From: Planning
Subject: FW: Planning Application 3/2021/0011

From:
Sent: 19 January 2021 14:10
To: Planning <planning@ribblevalley.gov.uk>
Subject: Planning Application 3/2021/0011

Dear Mr. Birkett,
We refer to the above planning application for the land between houses 34 and 40 George Lane, Read.
We would like to make the following observations:

sheet: os plan

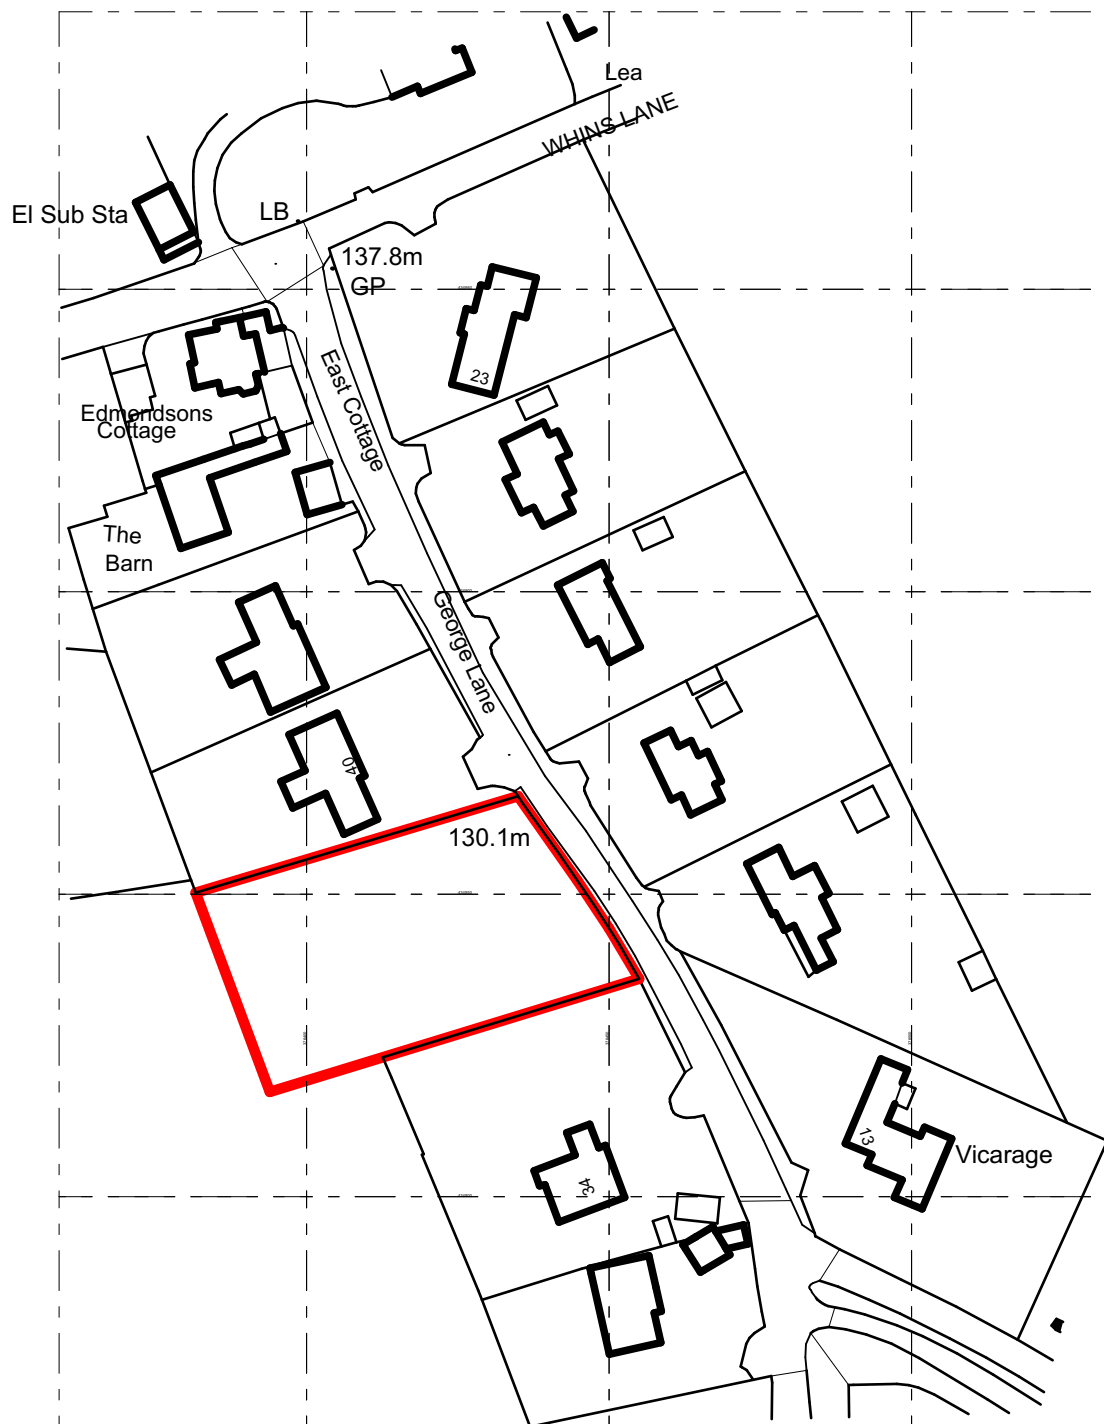
The plot of land extends well into Hammond Ground. In keeping with the boundary line of George Lane we believe that the border should run parallel to property number 34. This would mean that the plot is of similar size to its neighbours.
